NORWICH TO TILBURY

EN020027

Comments on Submissions received at Deadline 1

12 March 2026

Drawing Number: 10059280-ARC-EGN-ZZ-DR-ZZ-00882	Revision: A
--	----------------

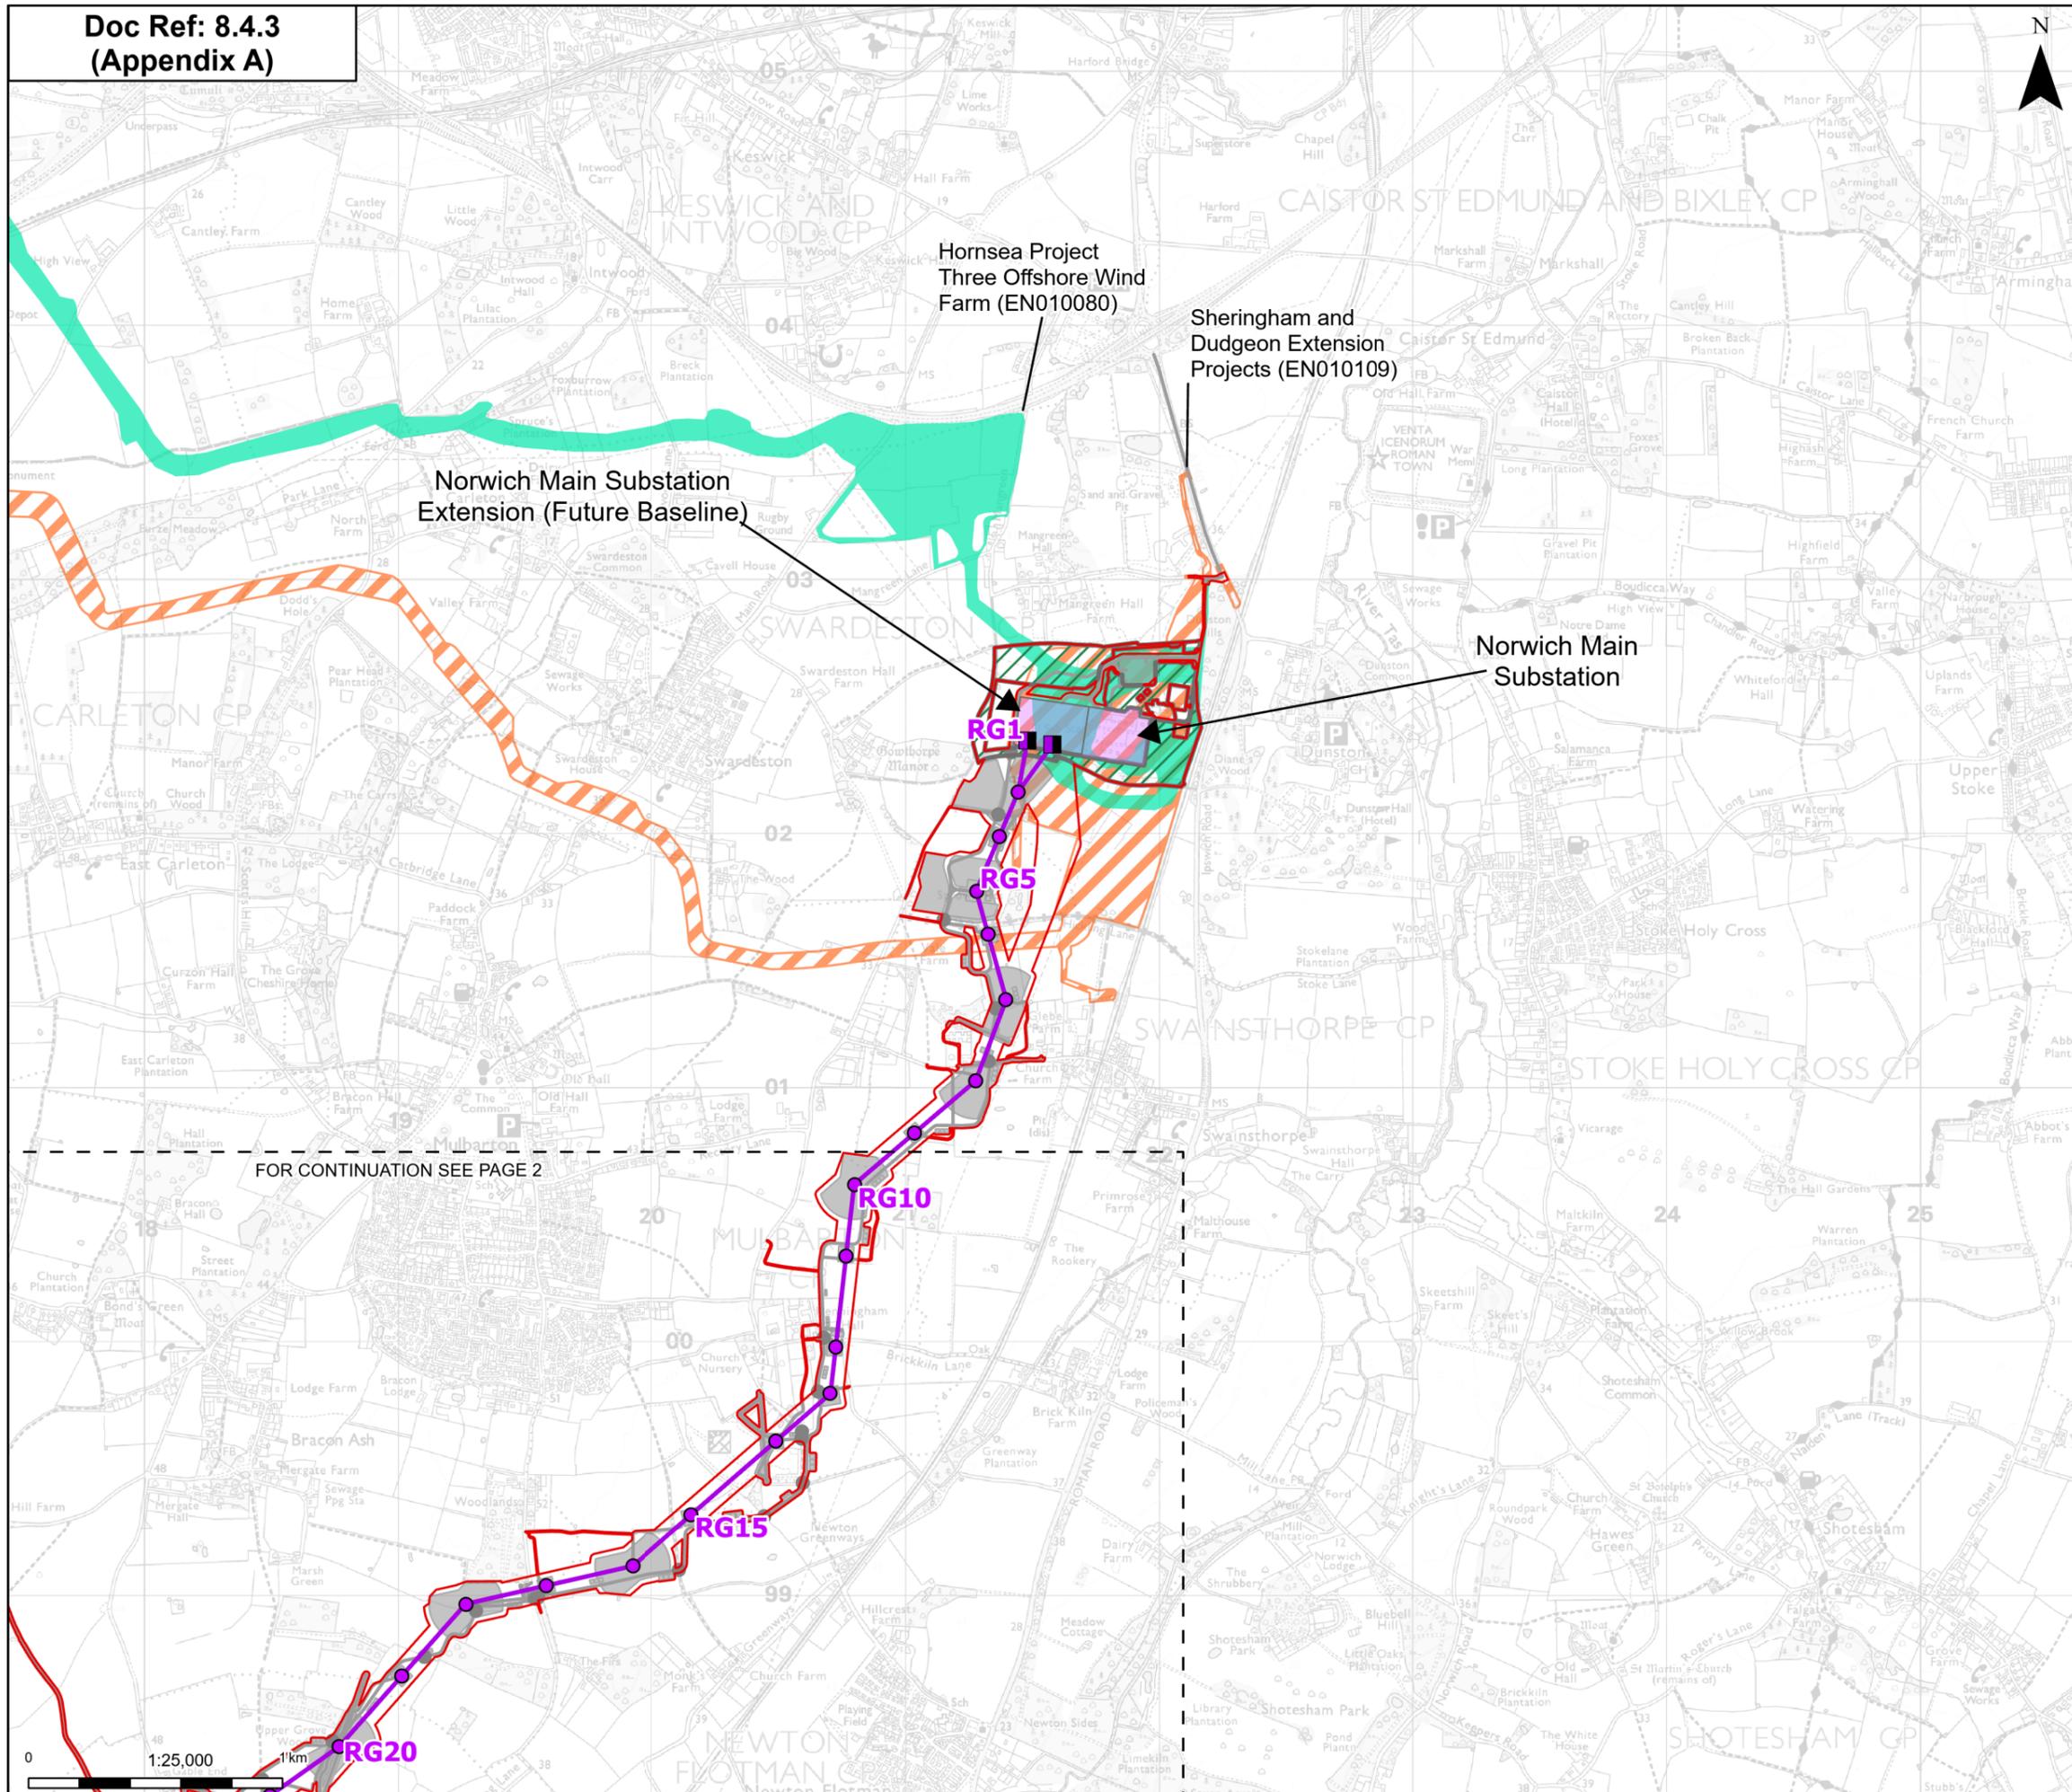
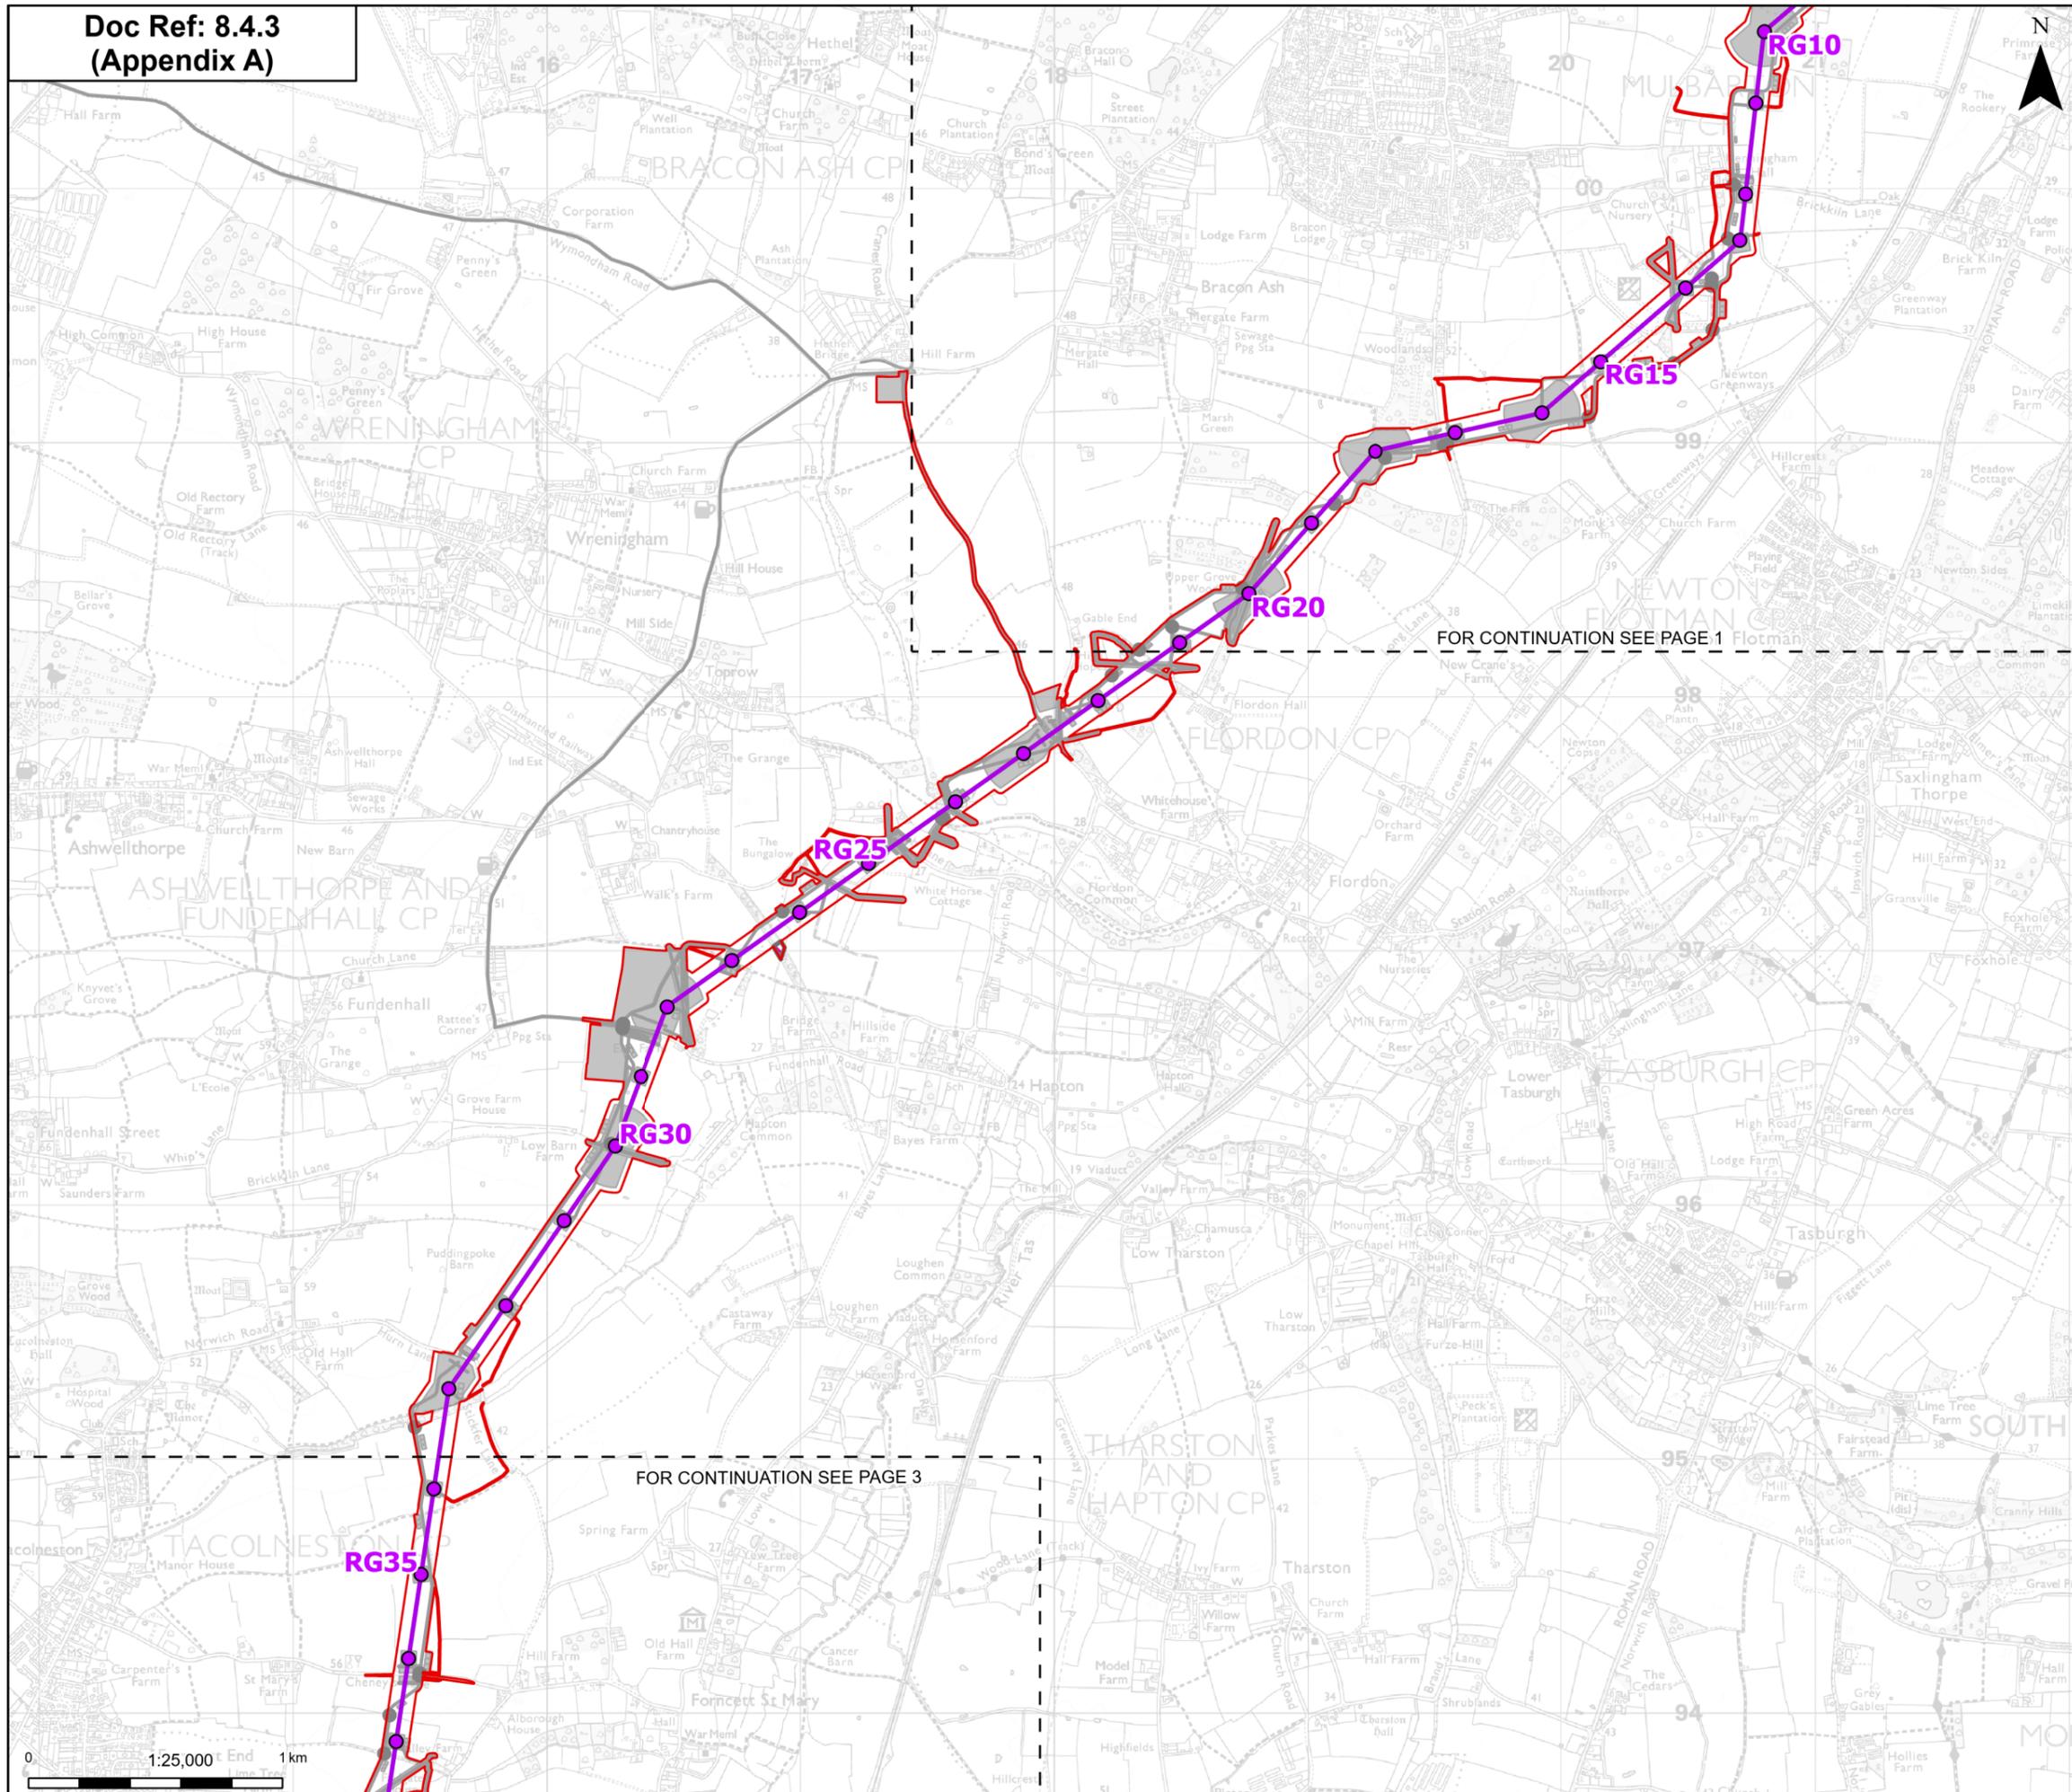
1l	Lead officer	Appendix A	The drafts order limits for the EcoPower Suffolk solar NSIP are not shown
